Kerry Hamann
Department Of Planning - Major Development Assessment
GPO Box 39
SYDNEY NSW 2001

SUBJECT: SMARTSKIP WASTE RECOVERY PROJECT (09_0025) OBJECTION TO DEVELOPMENT

I refer to the Department of Planning letter dated 2 February 2010 (your reference: S07/01151) regarding the public exhibition period for the Smartskip Waste Recovery Project (09_0025) located on Fariola Street, Silverwater and the invitation to make a submission on the project.

Figure 2: Current Site Access Arrangements – Fariola St

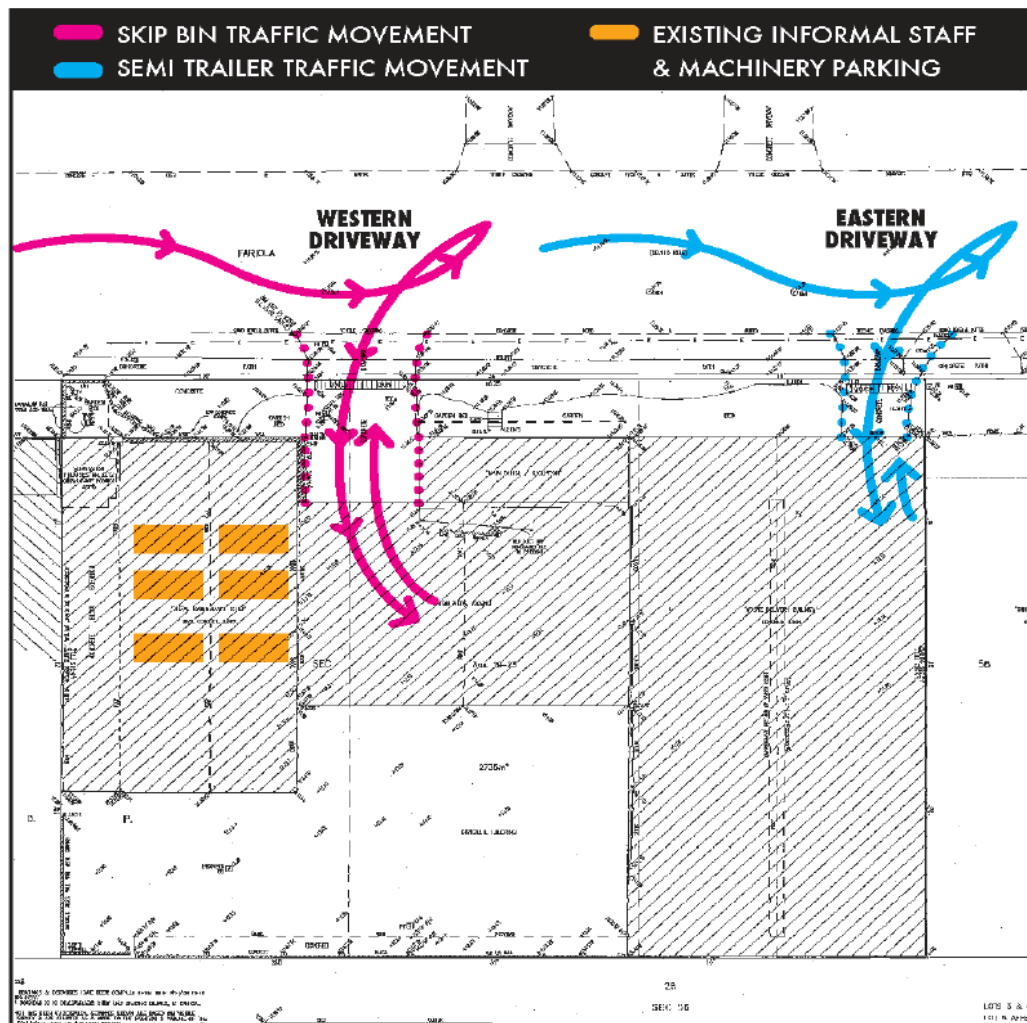
The proposed expansion is not supported on the basis that the site is not suitable for its intended expansion in that **all** vehicles required to access and service the site cannot enter and leave in a forward direction. The traffic impact assessment report prepared by Cardno Eppell Olsen proposes reverse manoeuvring of articulated vehicle in eastern driveway. This is not considered acceptable by Council, as it will have an adverse impact on the Fariola Street traffic, which is expected to exceed the capacity of the road as per the traffic report (part 3.4 of the Traffic Report, Appendix 7 of the Statement)

Complaints have been received by Council over an extended period of time regarding traffic interference at the site by "Smartskip" trucks reversing into the site (it is noted that the facility appears to be already operating at an increased capacity beyond the scope of the existing approval granted by Auburn City Council).

GROUND FLOOR PLAN

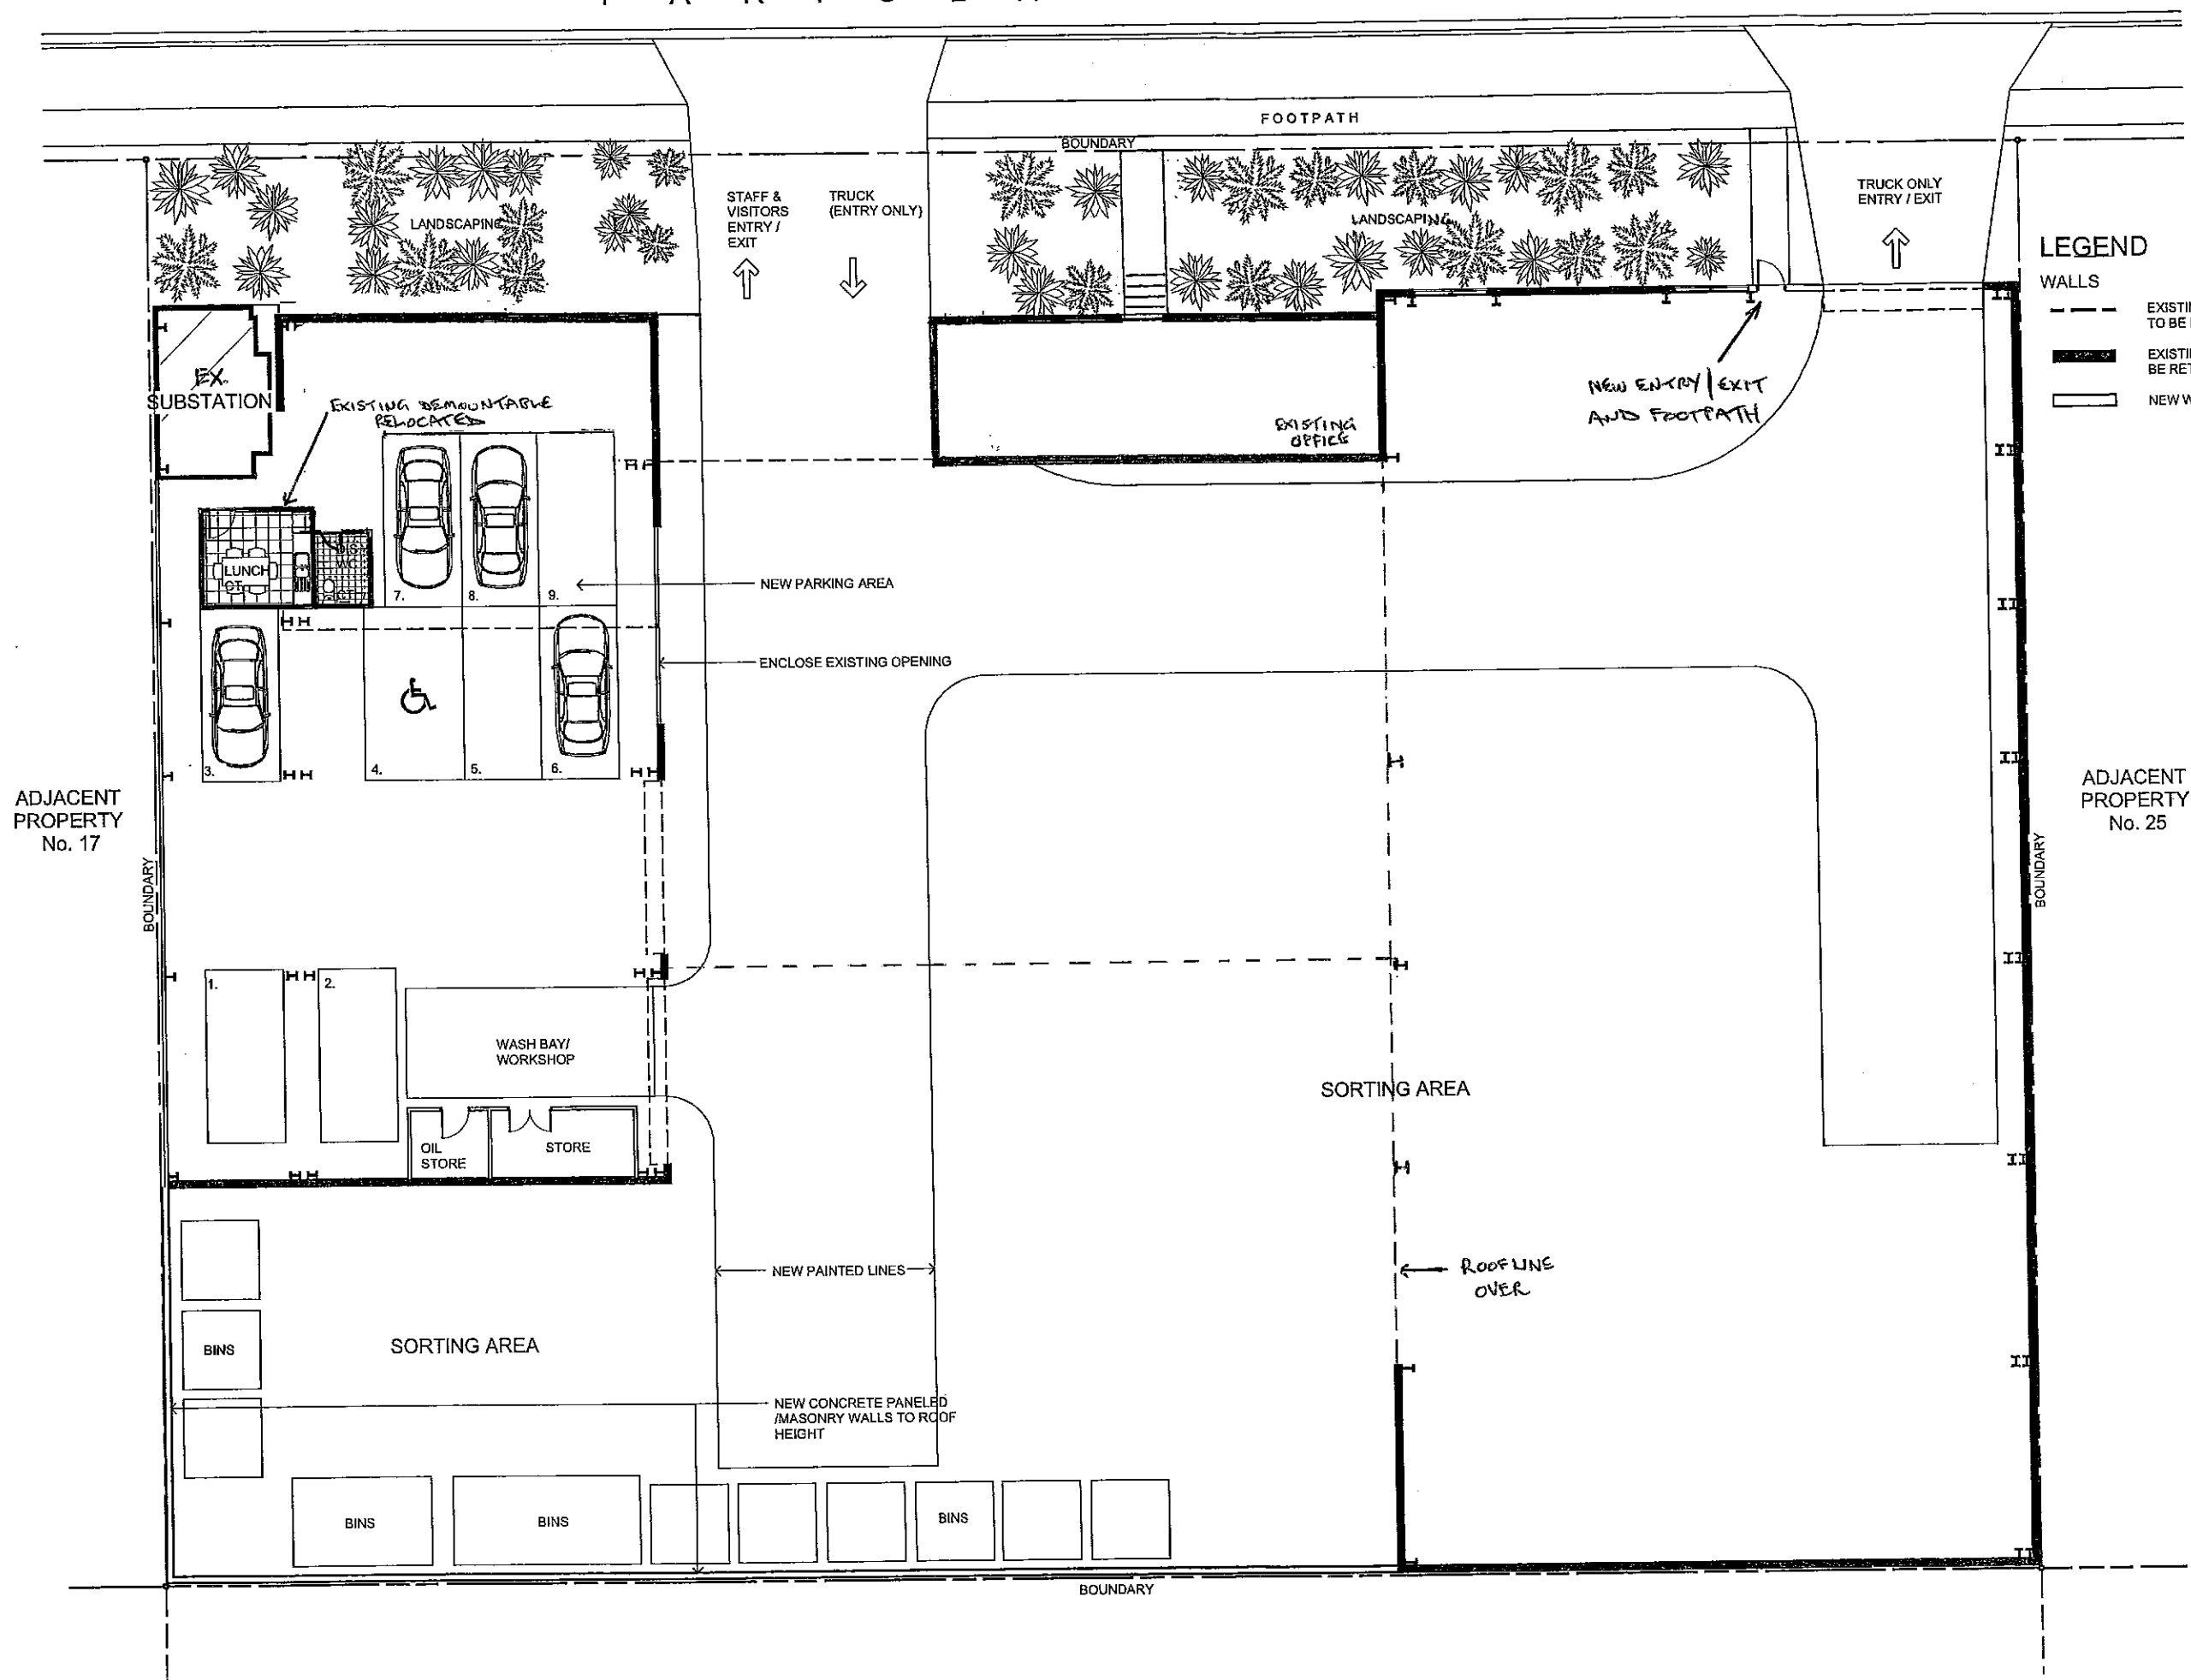
The proposed washbay area should be bunded and all runoff should be connected to an industry standard oil and silt separator device prior to an approved drainage point.

The main sorting areas should have an industry standard siltation and debris capture system or pit to intercept silt and debris prior to any connection into the Stormwater Drainage System. A suitable maintenance plan detailing the frequency for checking and clearing of the separator should also be submitted for consideration.
